CITY OF ALBUQUERQUE

February 25, 2019

Re: BEK Distribution Facility
601 Gallatin Pl. NW Albuquerque NM 87121
Traffic Circulation Layout
Engineer's/Architect's Stamp ??-??-?? (J10D00261)

Based upon the information provided in your submittal received XX-XX-19, the above referenced plan cannot be approved for Building Permit until the following comments are addressed:

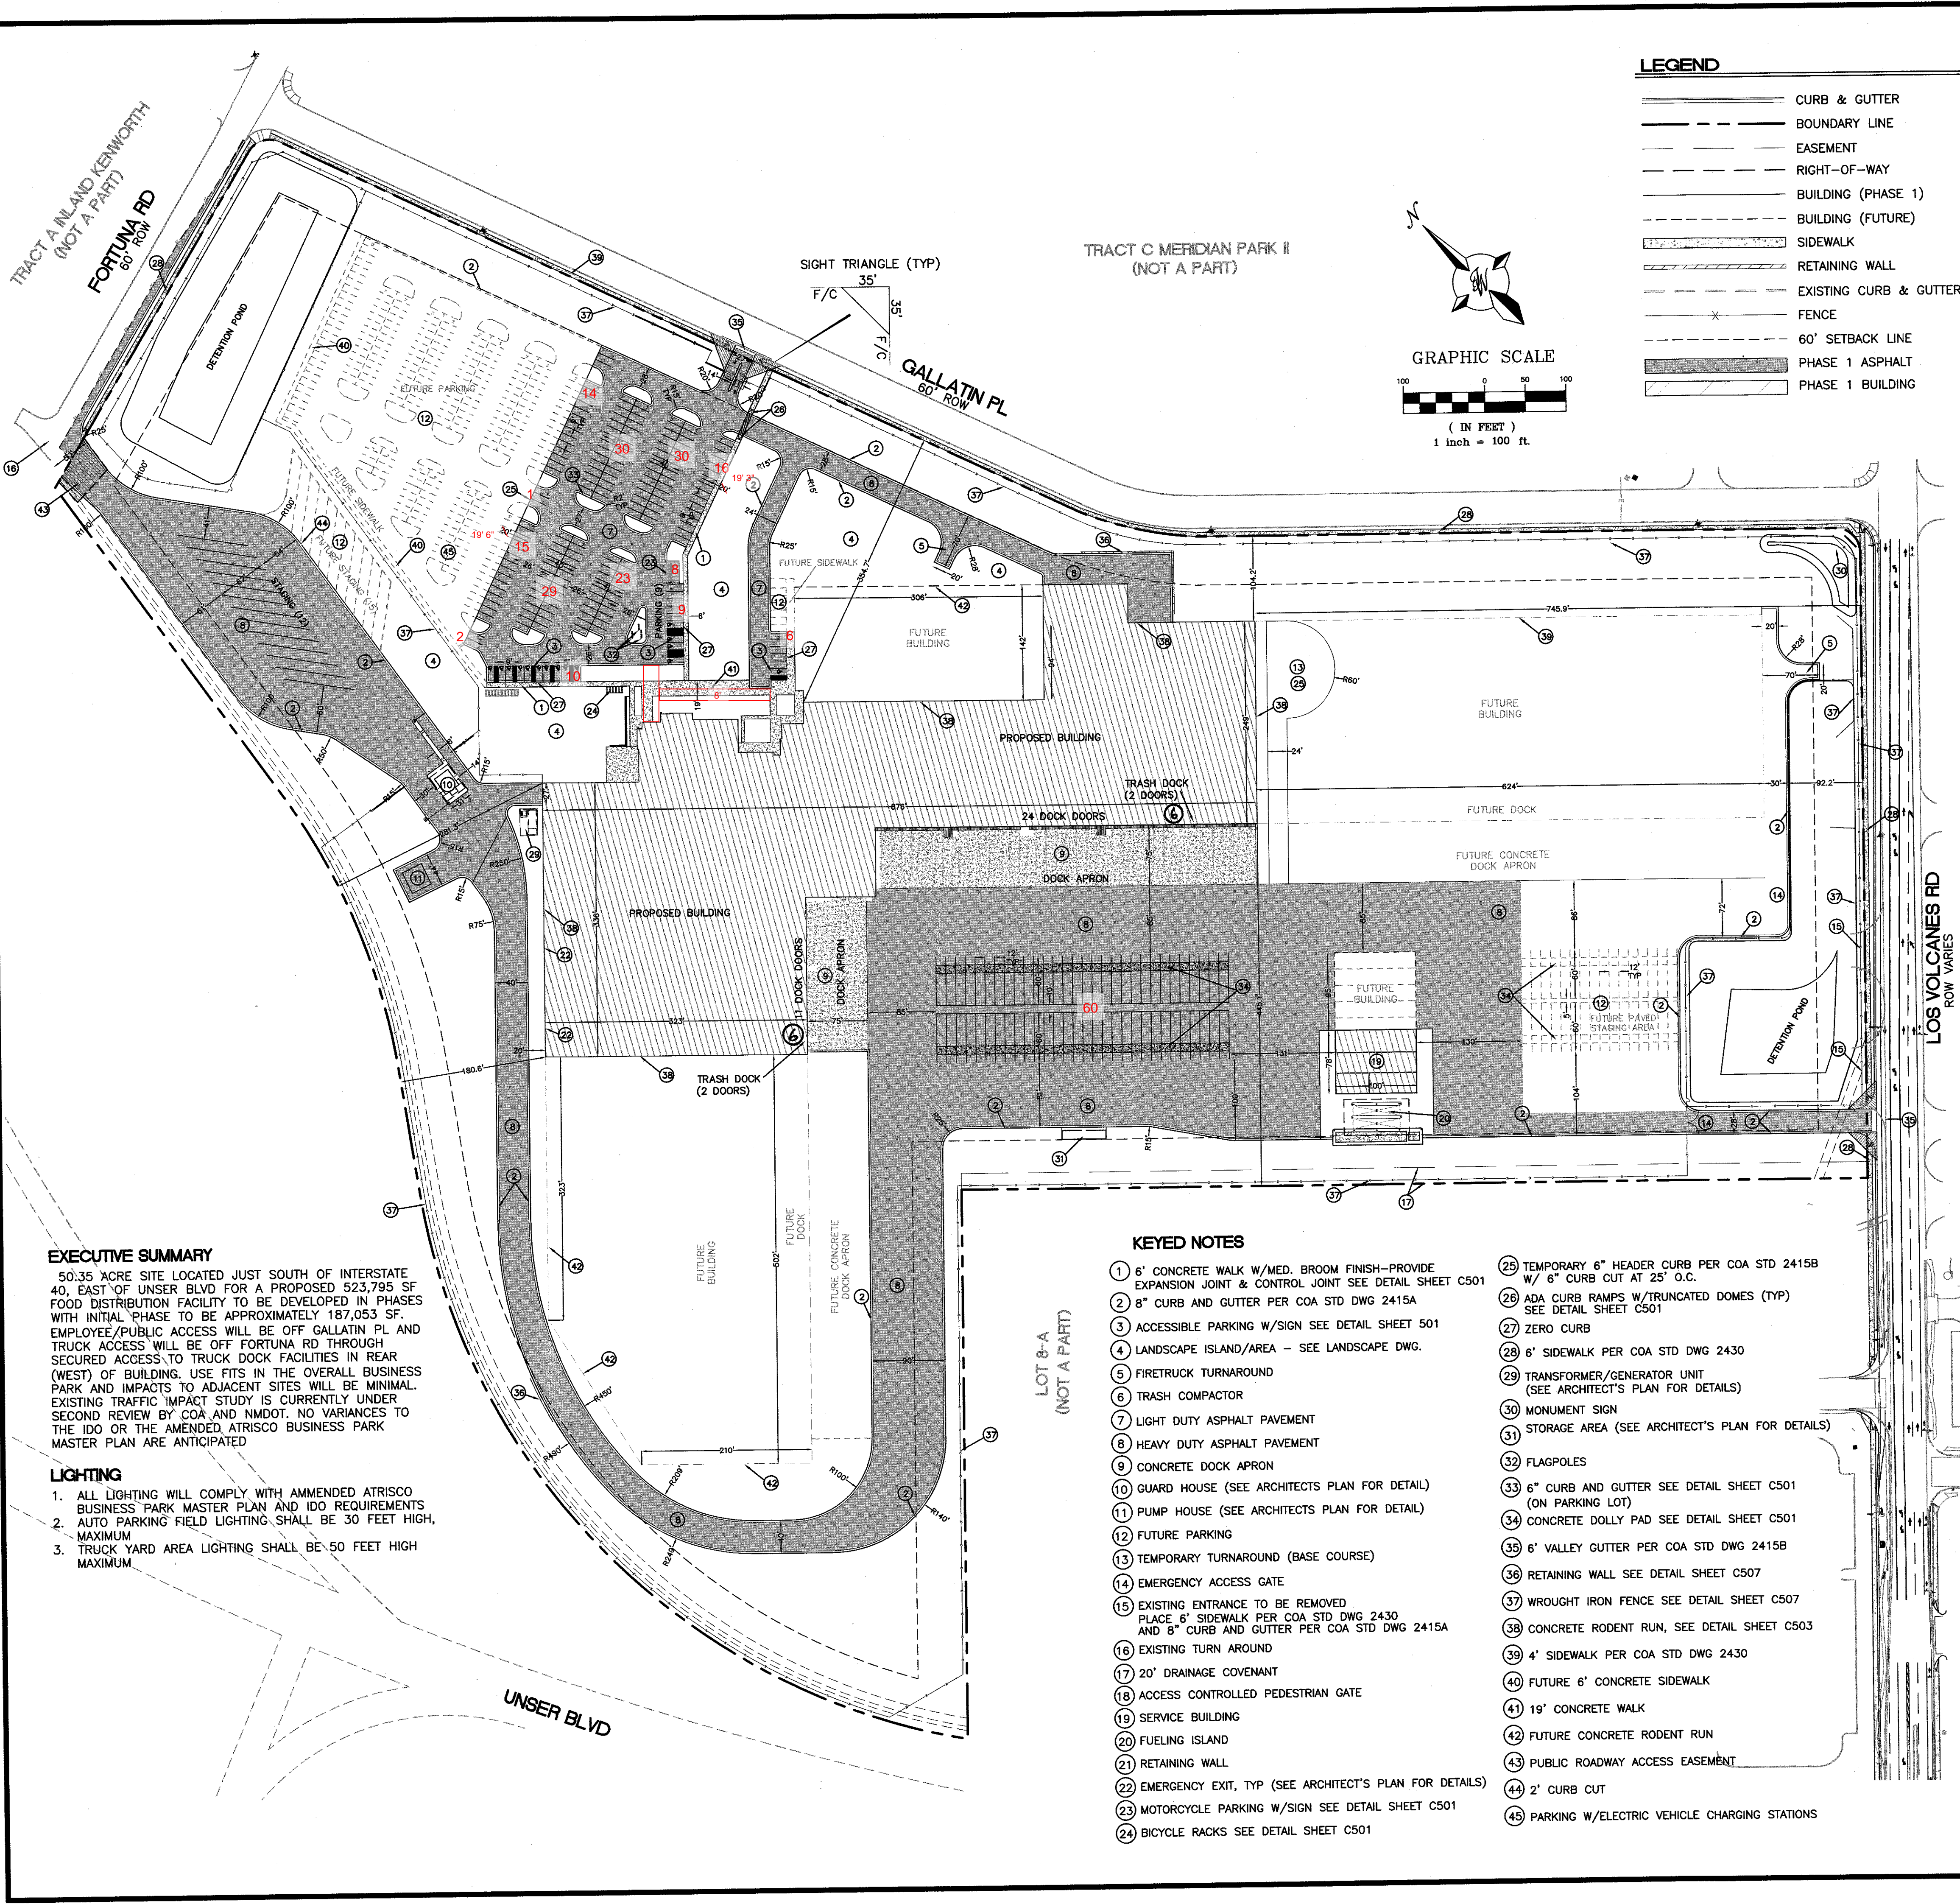
1. The traffic circulation layout must be stamped, signed, and dated by an engineer or architect licensed in the state of New Mexico.
2. Please list the width and length for all existing and proposed parking spaces. Some dimensions are not shown.

3. The handicap accessible spaces must be a minimum of 8.5 ft. in width.
4. The handicap accessible spaces must include an access aisle. Van accessible aisles should be 8ft wide; all others should be 5ft wide.

5. The ADA accessible parking sign must have the required language per 66-7-352.4C NMSA 1978 **"Violators Are Subject to a Fine and/or Towing."** Please call out detail and location of HC signs.

6. The ADA access aisles shall have the words **"NO PARKING"** in capital letters, each of which shall be at least one foot high and at least two inches wide, placed at the rear of the parking space so as to be close to where an adjacent vehicle's rear tire would be placed. (66-1-4.1.B NMSA 1978)

7. ADA curb ramps must be updated to current standards and have truncated domes installed.
8. Motorcycle parking spaces shall be designated by its own conspicuously posted upright sign, either free-standing or wall mounted per the zoning code.

9. A 5 ft. keyway is required for dead-end parking aisles.
10. All sidewalks along streets should be placed at the property line. And please provide details for the sidewalk.

11. Service vehicle and/or refuse vehicle maneuvering must be contained on-site; provide a copy of refuse approval.
12. Please provide paving details such as the asphalt type and the cross section.
13. An approved TIS is needed before TCL approval.
14. Please verify what is going on in the circled area in the picture. Are those areas part of future parking structure? If not, the 400 ft long row of parking with no internal circulation is not acceptable.
